Item No. **Report of the Head of Development Management and Building Control**

Address: TESCO EXPRESS, 122-124 HIGH STREET RUISLIP

Development: Change of use of part of the rear of the building and upper floors from Class E (Commercial, Business and Service) to Class C3 (Dwelling-houses) in order to create six residential dwellings alongside associated works.

LBH Ref Nos: 11894/APP/2024/3030

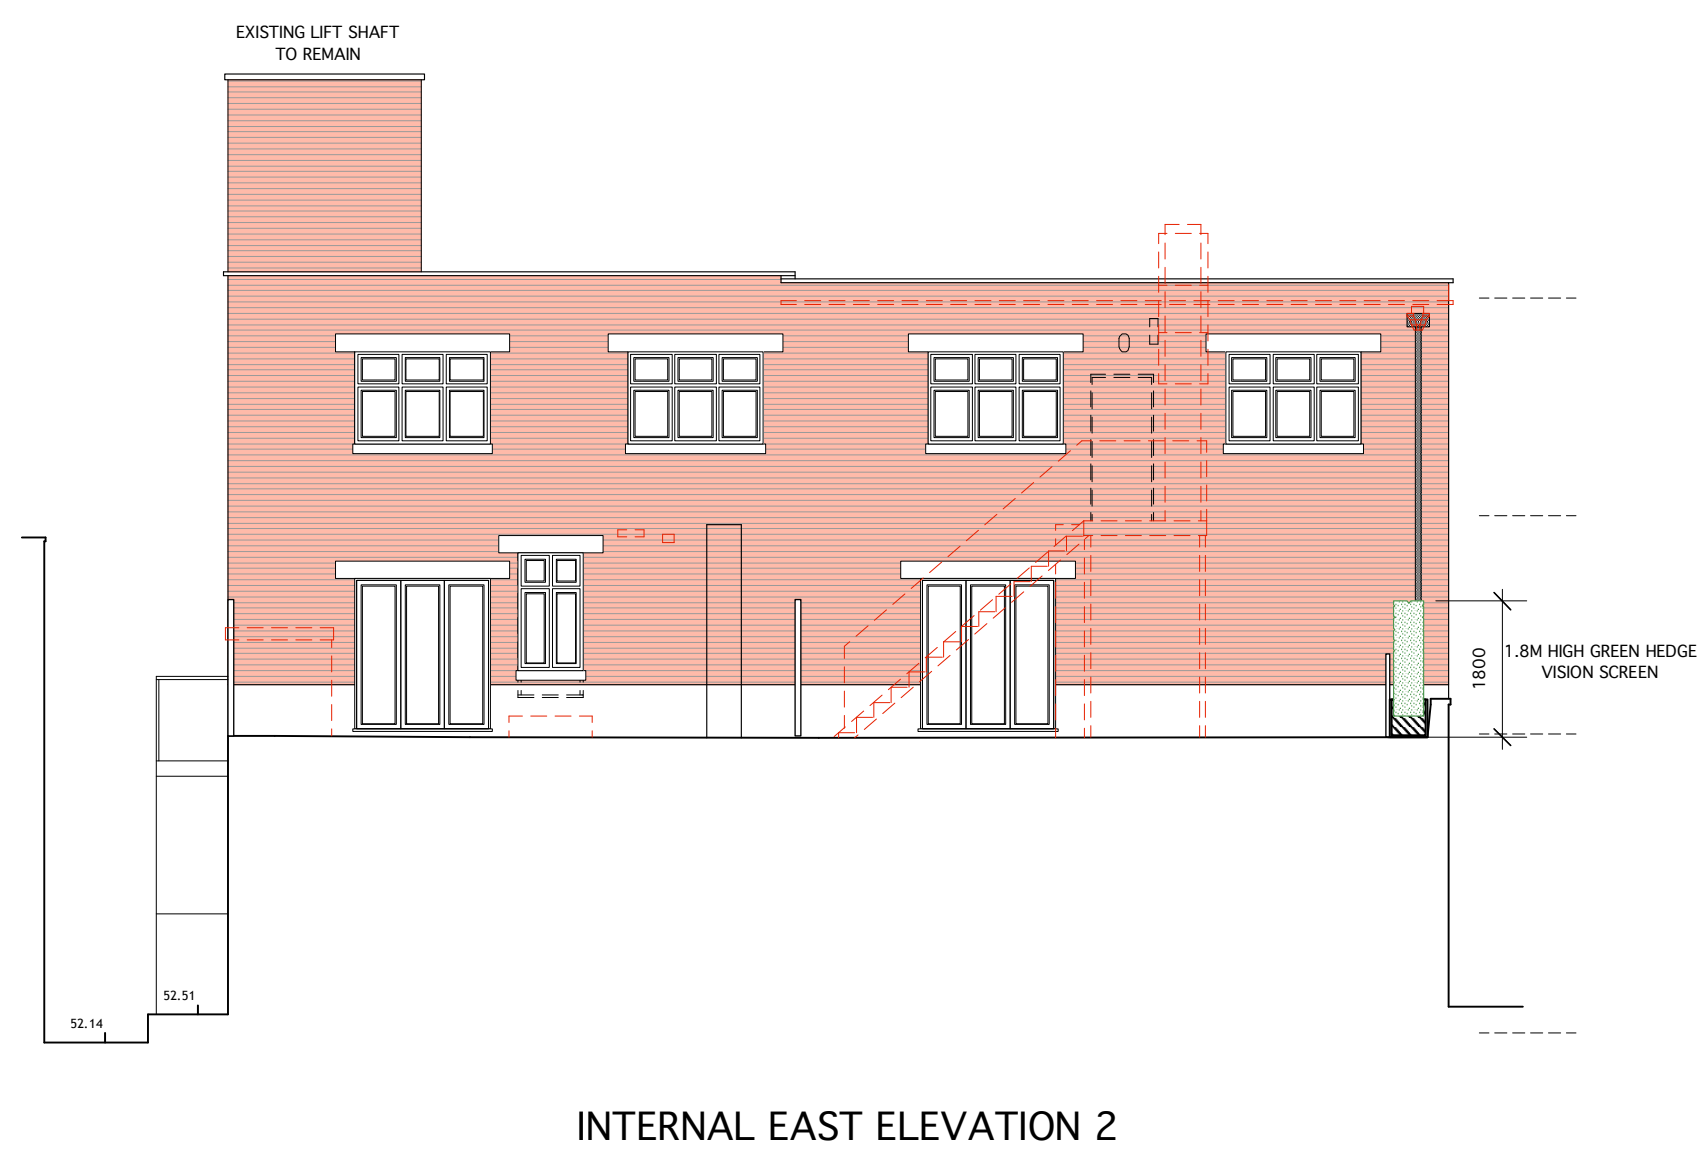
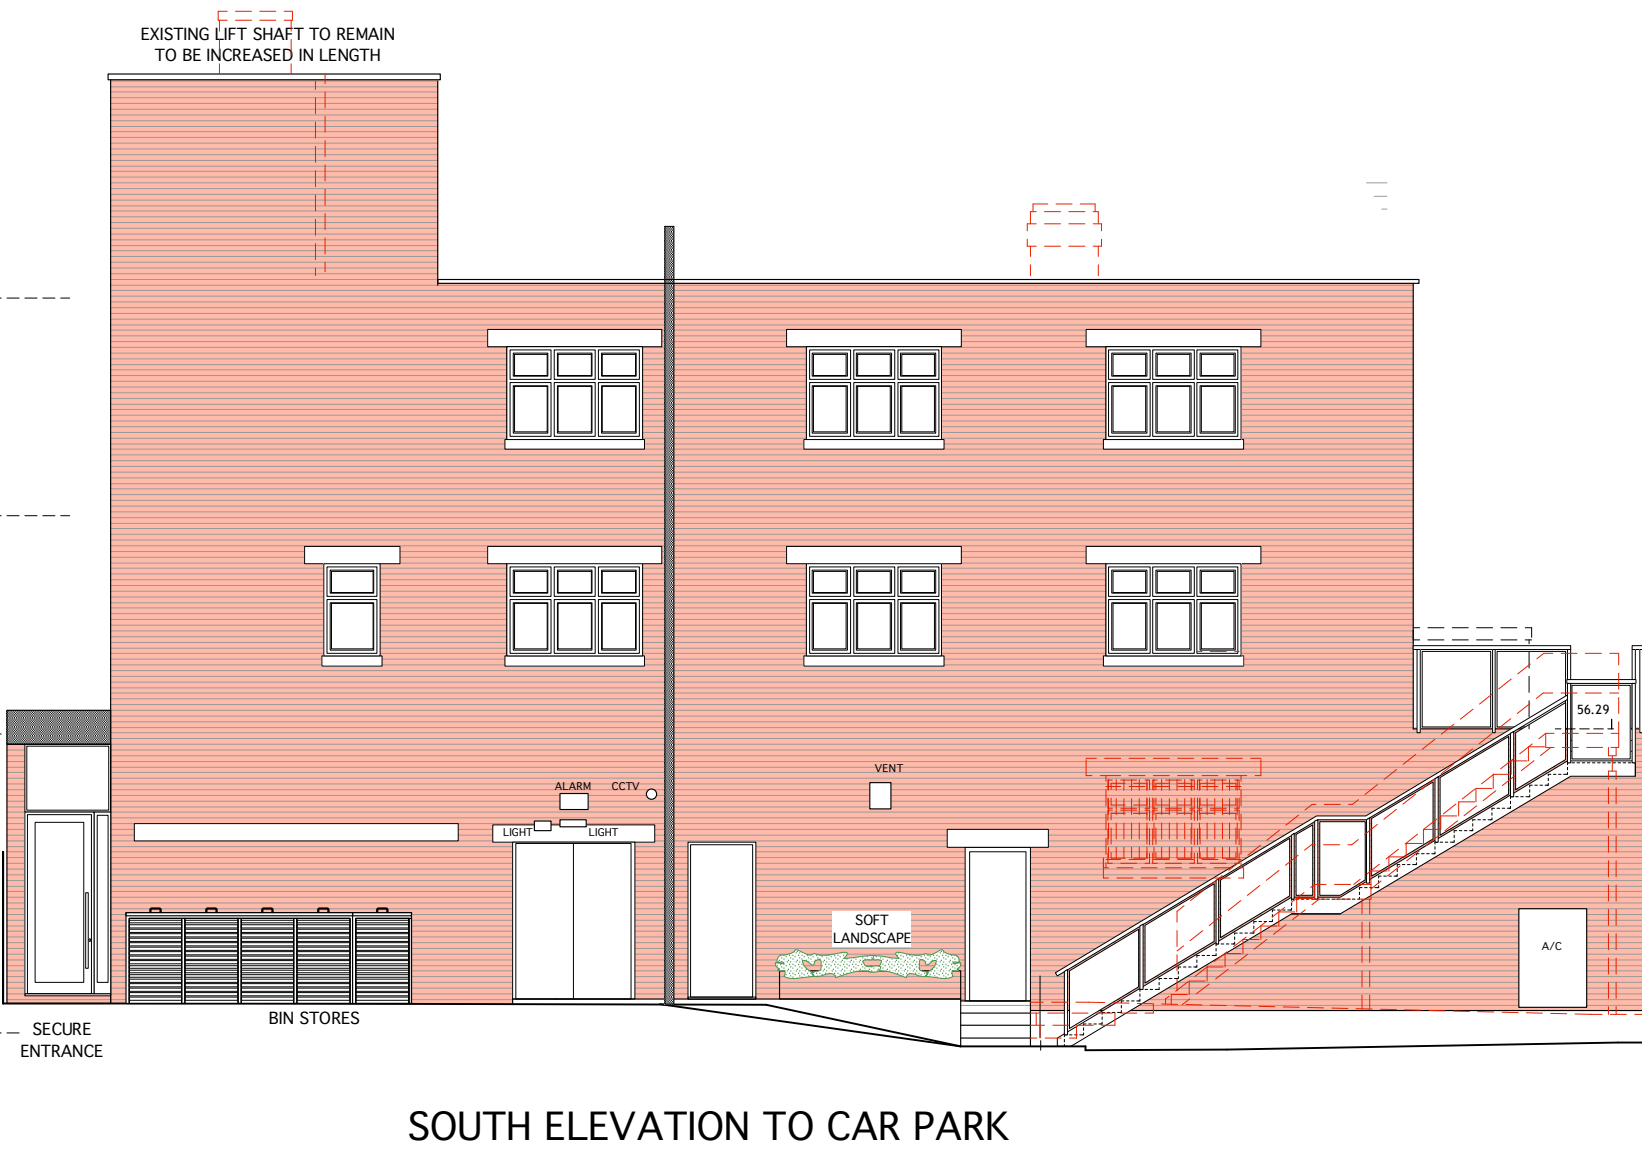
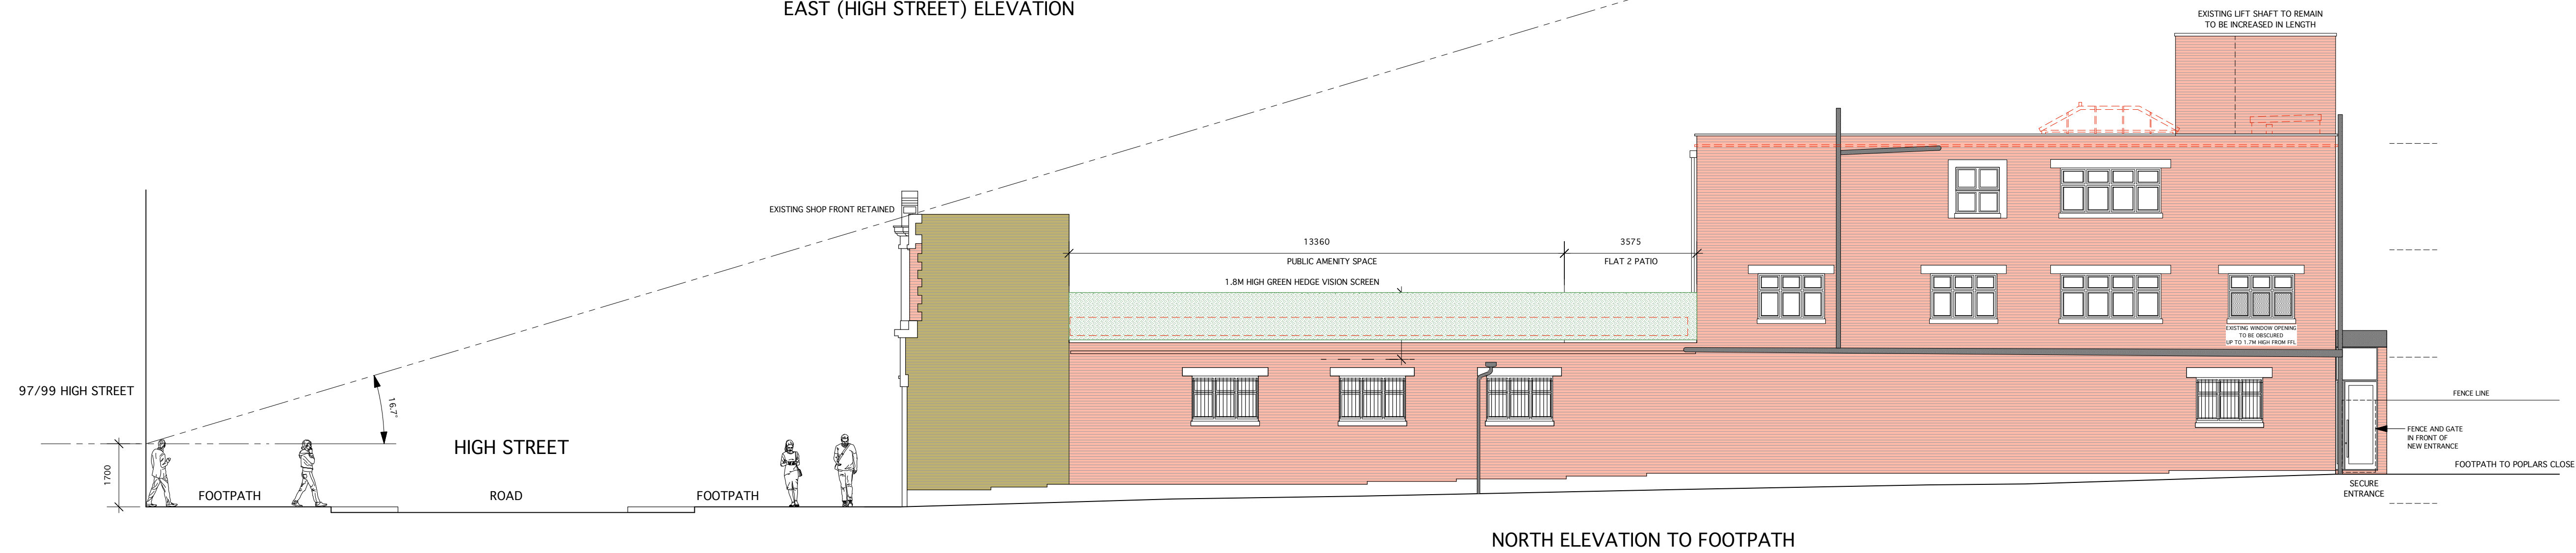
6.The bins are laid out in a utilitarian manner, unintegrated with the building, and appear to lack screening or enclosure. While this area may be considered back-of-house (BOH), we would still expect some level of visual integration / screening.

It is noted that the Design Officer has raised concerns about the bins which are laid out in a utilitarian manner, unintegrated with the building, which appear to lack screening or enclosure. These details could be secured by condition.

FIRST FLOOR PLAN

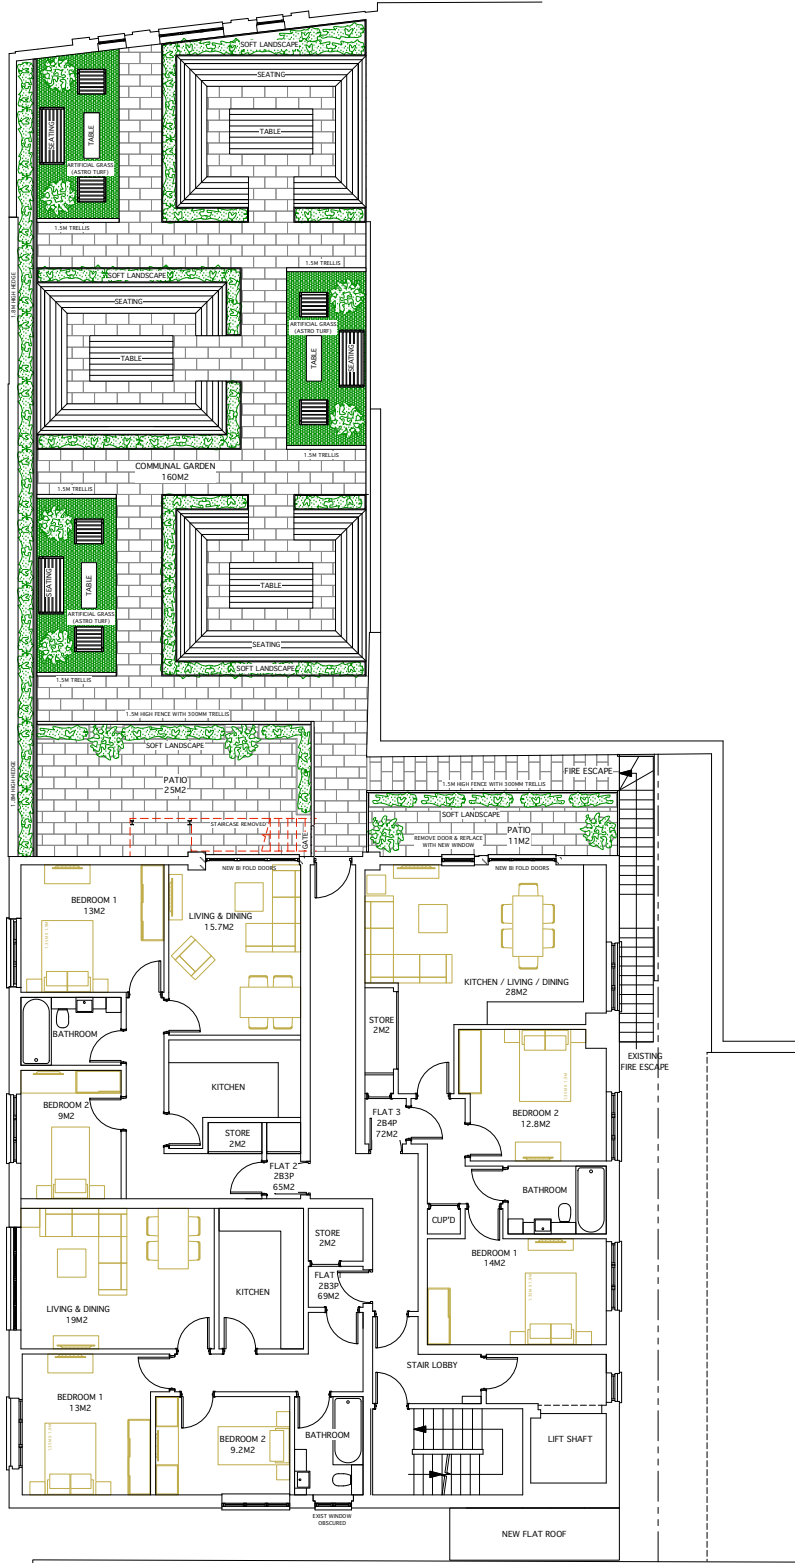
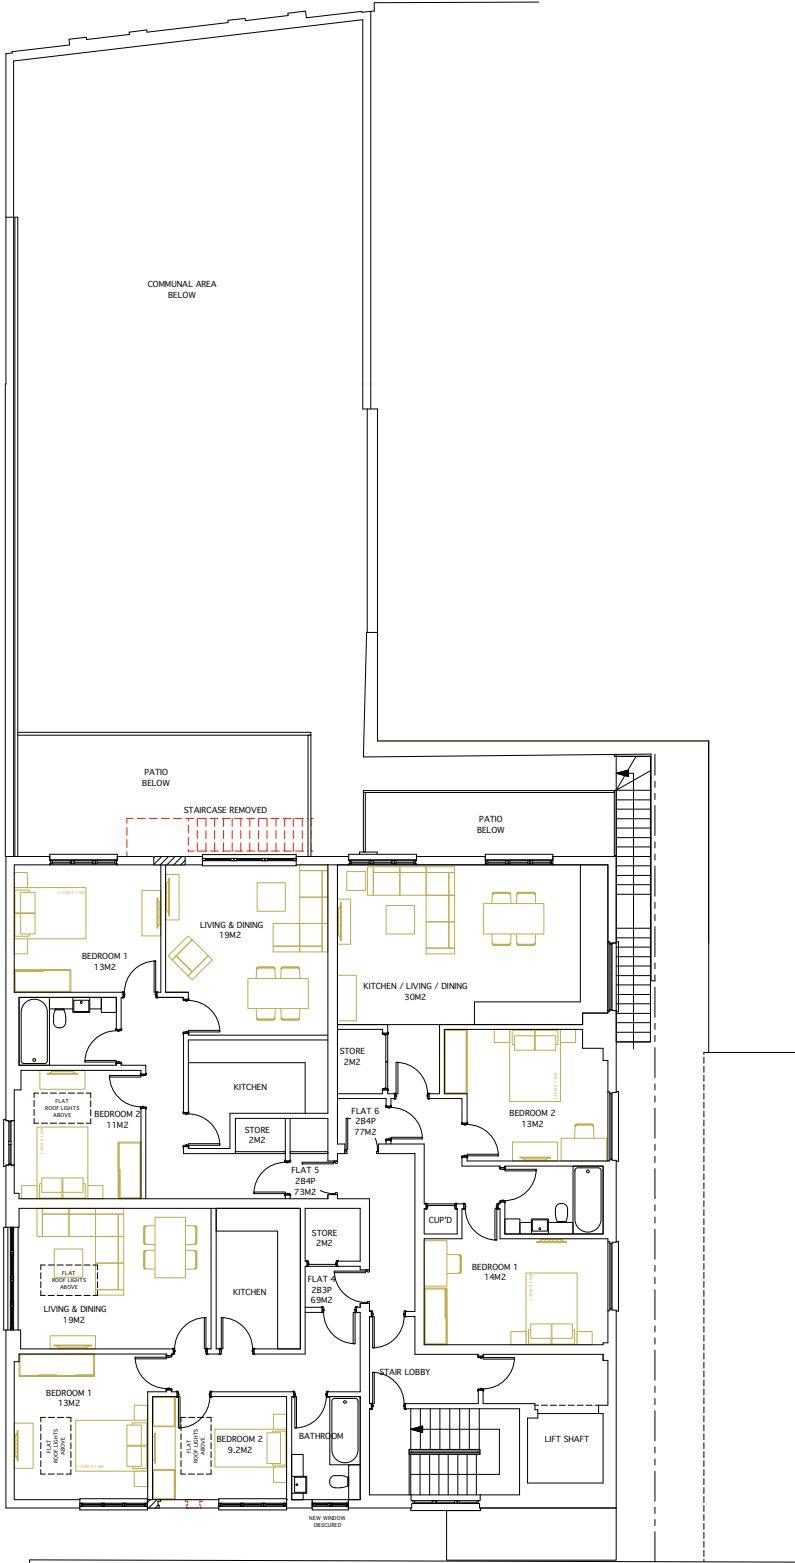
The private amenity space provide is not adequate in terms of quantity and quality and would be overlooked. In addition, due to the use of boundary treatment to demarcate private amenity occupiers of Flat 2 and Flat 3 would experience a loss of outlook and privacy given the proximity to the proposed 1.5m high fence and 300mm trellis. Further, Flat 1 and Flat 4 would not benefit from adequate outlook. Therefore, the development would fail to provide a high quality internal amenity space and external usable amenity space resulting in harm to residential amenity and unsatisfactory living conditions for the occupiers. The development therefore conflicts with Policies DMHB 11 and DMHB 18 of the Hillingdon Local Plan: Part 2 - Development Management Policies (2020) and Policy D3 of the London Plan (2021).

Harm to residential amenity and unsatisfactory living conditions for the occupiers. - The windows for all habitable rooms in Flat 1 on the first floor and Flat 4 on the second floor will be obscured glass up to 0.7 m high. The occupants will not benefit from adequate outlook. - Patios for Flats 2 and 3 measure 25 and 11m². So the patio area for Flat 3 is significantly short of the recommended 25m², and both patios will be overlooked from Flats 5 and 6 above that will also overlook the communal
